Contact: Julia Ryl  
Our Ref: DA 52/2025/3/1  
Your Ref: SSD-49283708

**Request for Comment – State Significant Development**

**Description of Development – Residential Care Facility comprising ninety-six (96) beds**

DESIGNED NJC	DRAWN MJL	CHECKED NJC
DATE 27-07-23	SCALE/S AS NOTED	ISSUE B
DRG NO LC2667-SMP1

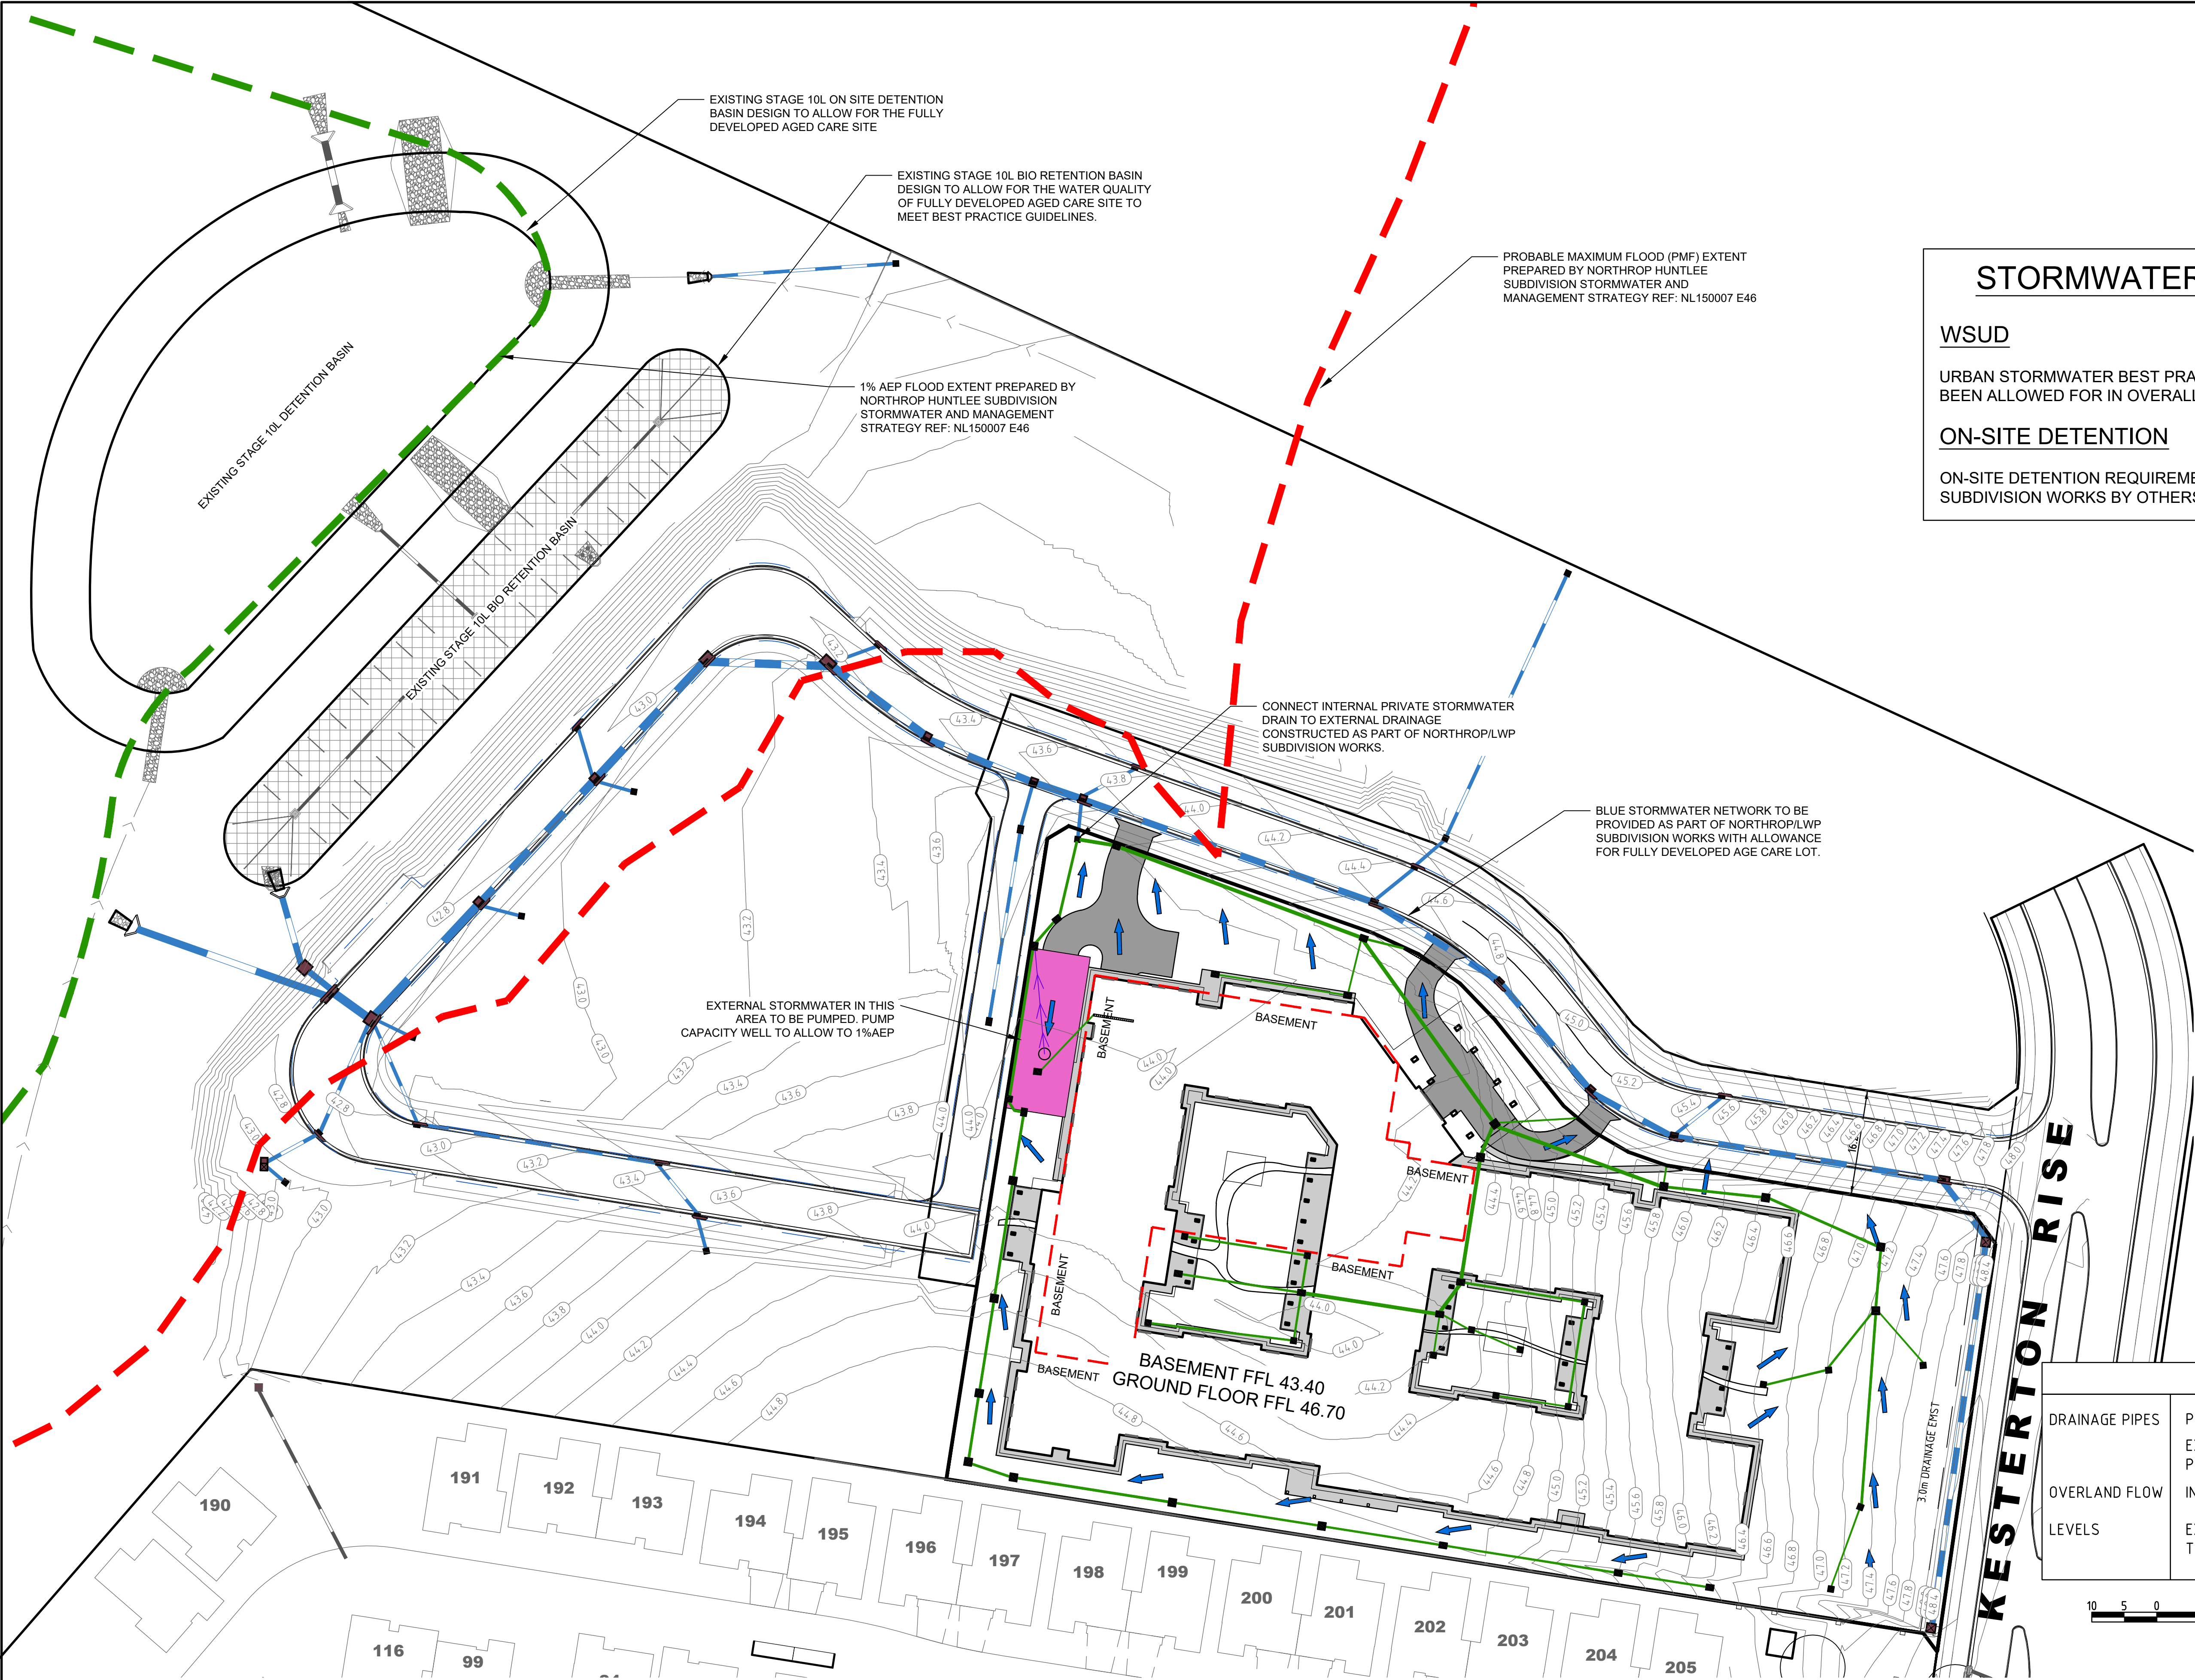
4. In relation to stormwater management the proponent is to ensure that the offsite discharge does not exceed stormwater infrastructure capacity in the roadways, as required by the civil design for the underlying Huntlee subdivision works.
5. The proposed car parking and shift rotation is considered compliant with car parking requirements for the proposed residential care facility. Car parking areas are to be kept clear of waste and no storage is to occur within designated car parking spaces, which would alter the number of available car parks from those demonstrated in the information provided for review.

1.8m HIGH SOLID FENCE ON TOP OF RETAINING WALL
Fence Type: Acoustic Max75
Acrylic Paint Finish Walls: Monument

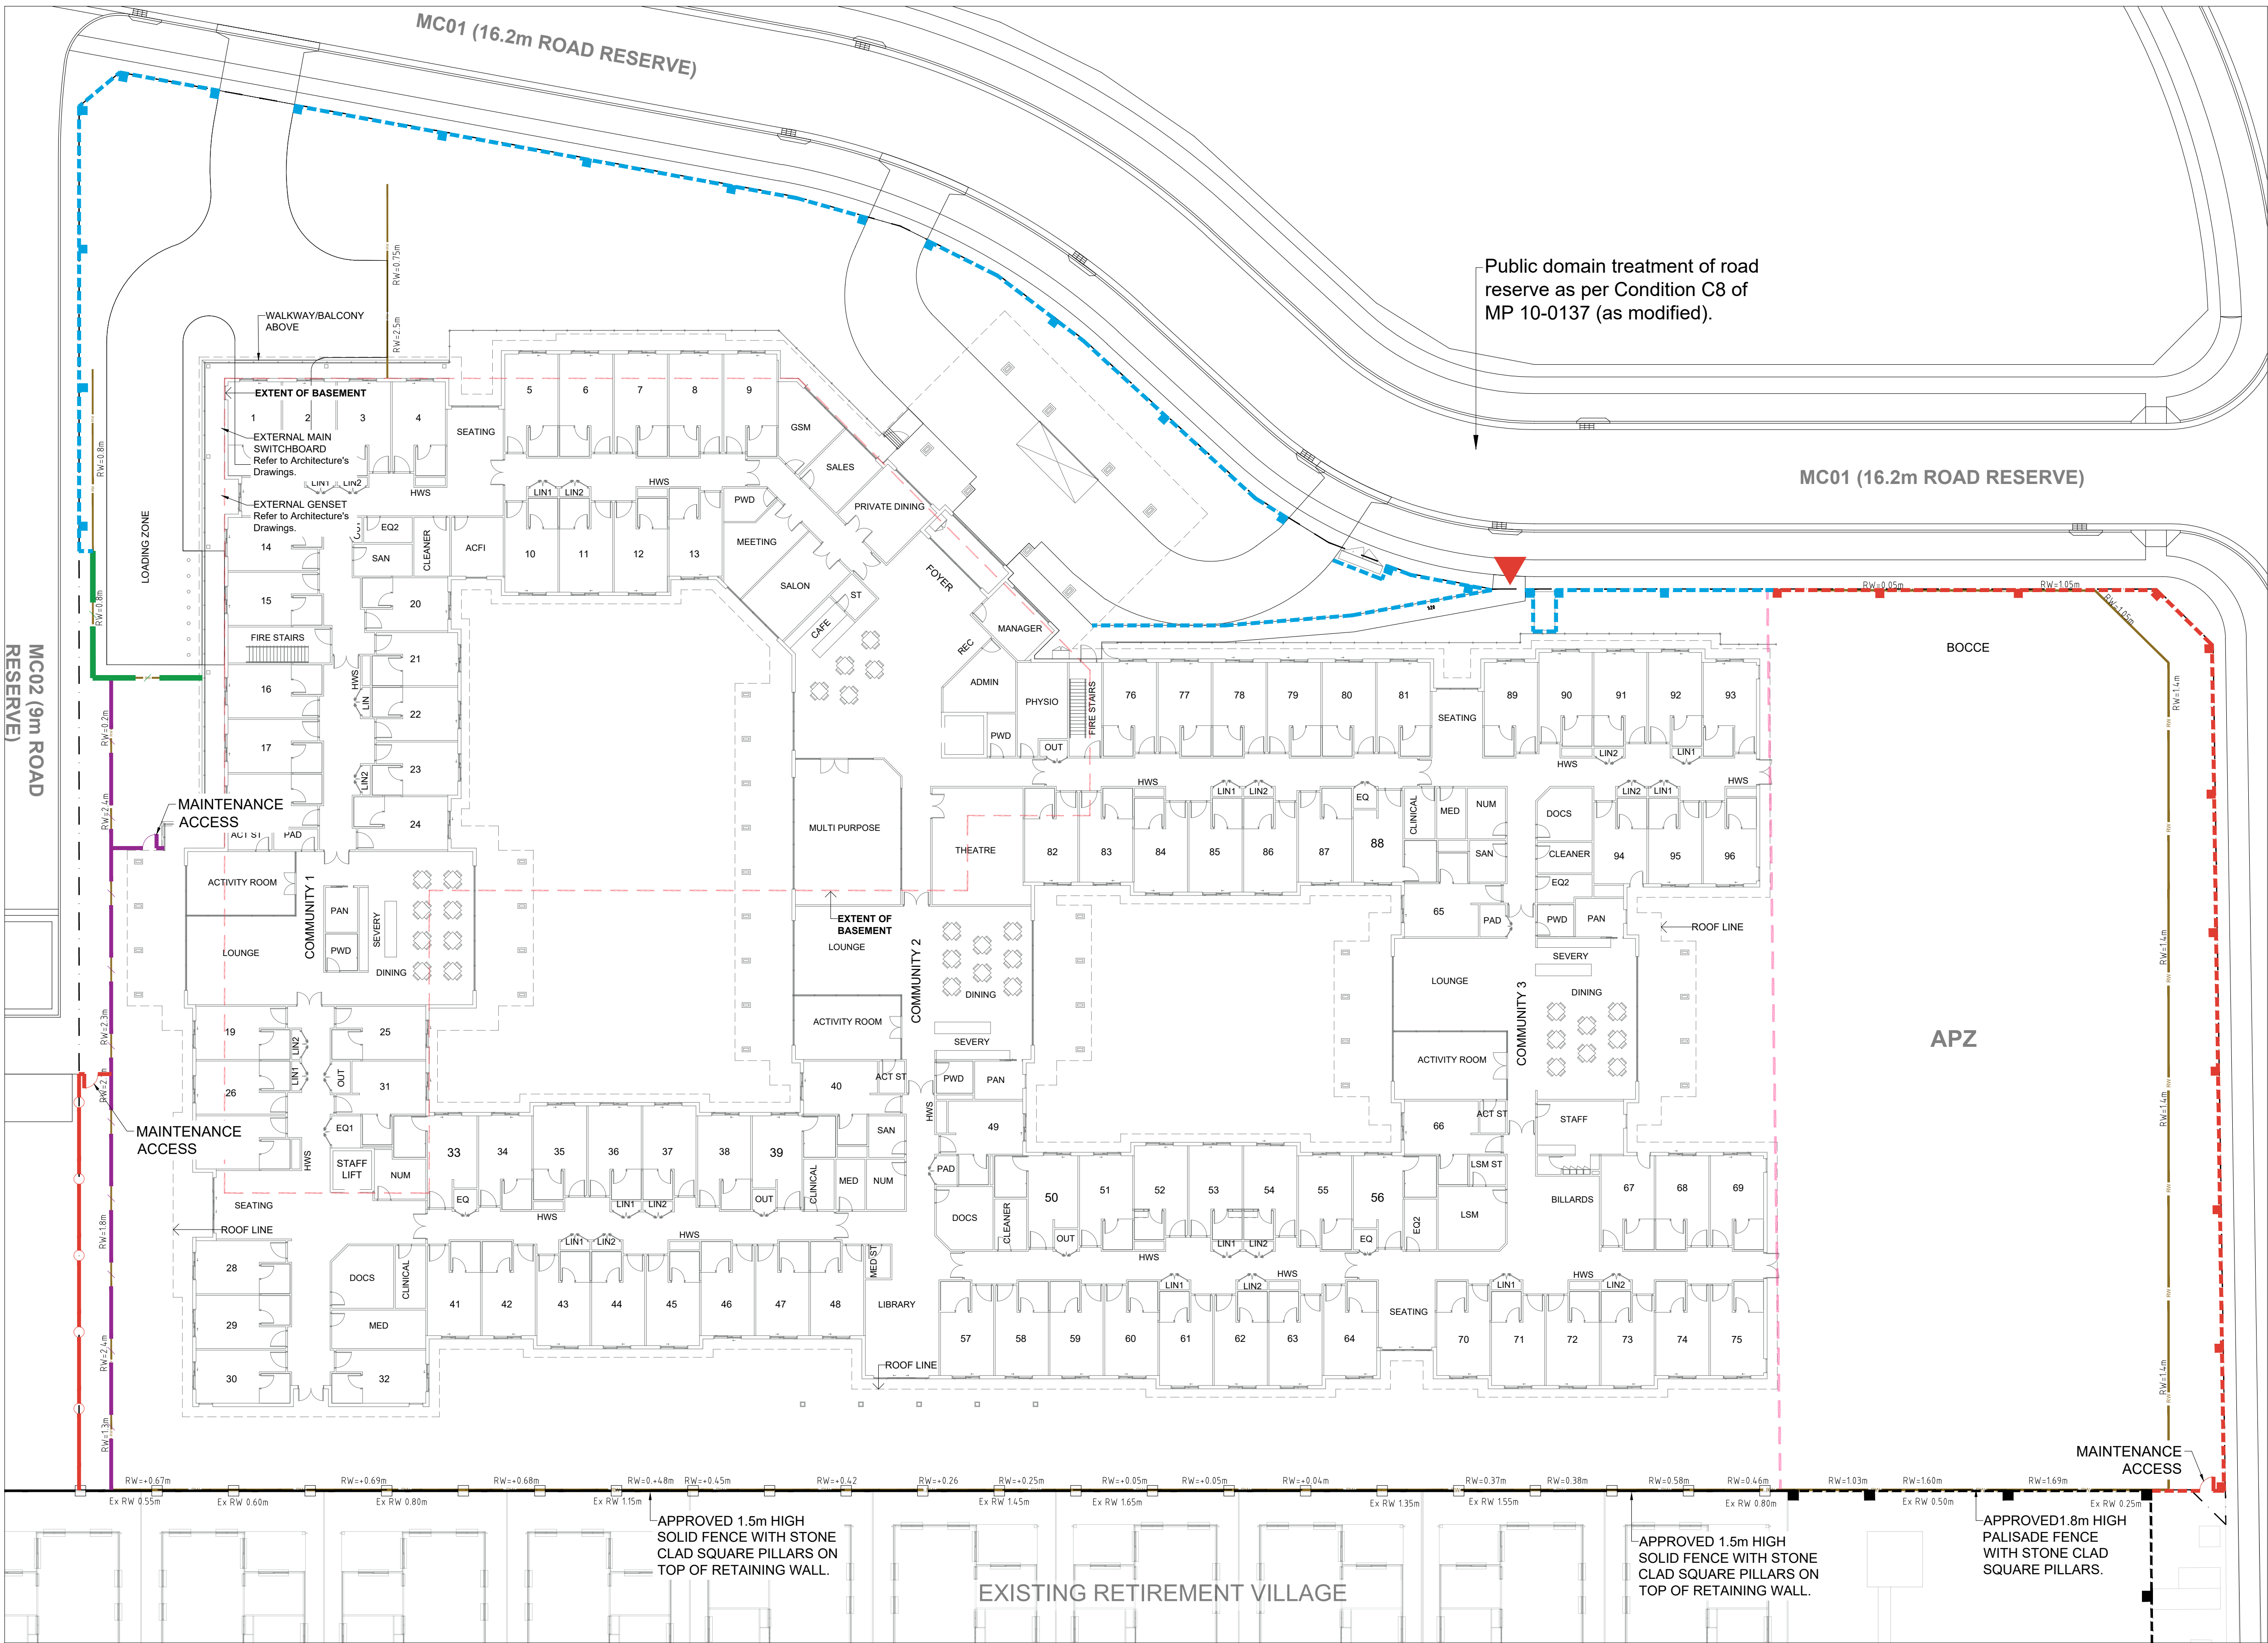
8. The western façade of the residential care facility development will interface with the intersection of future public roads MC02 and MC01, this will present a maximum 2.3m retaining wall with fencing provided atop. Although located setback within the lot boundary and planting proposed by the landscape plan. Council suggests consideration of low plantings for this portion of external wall be incorporated with a public art installation, such as a mural. This may assist with deterrence of graffiti on external walls, particularly in consideration of less visual surveillance from the main entry points to the proposed residential care facility along this façade.
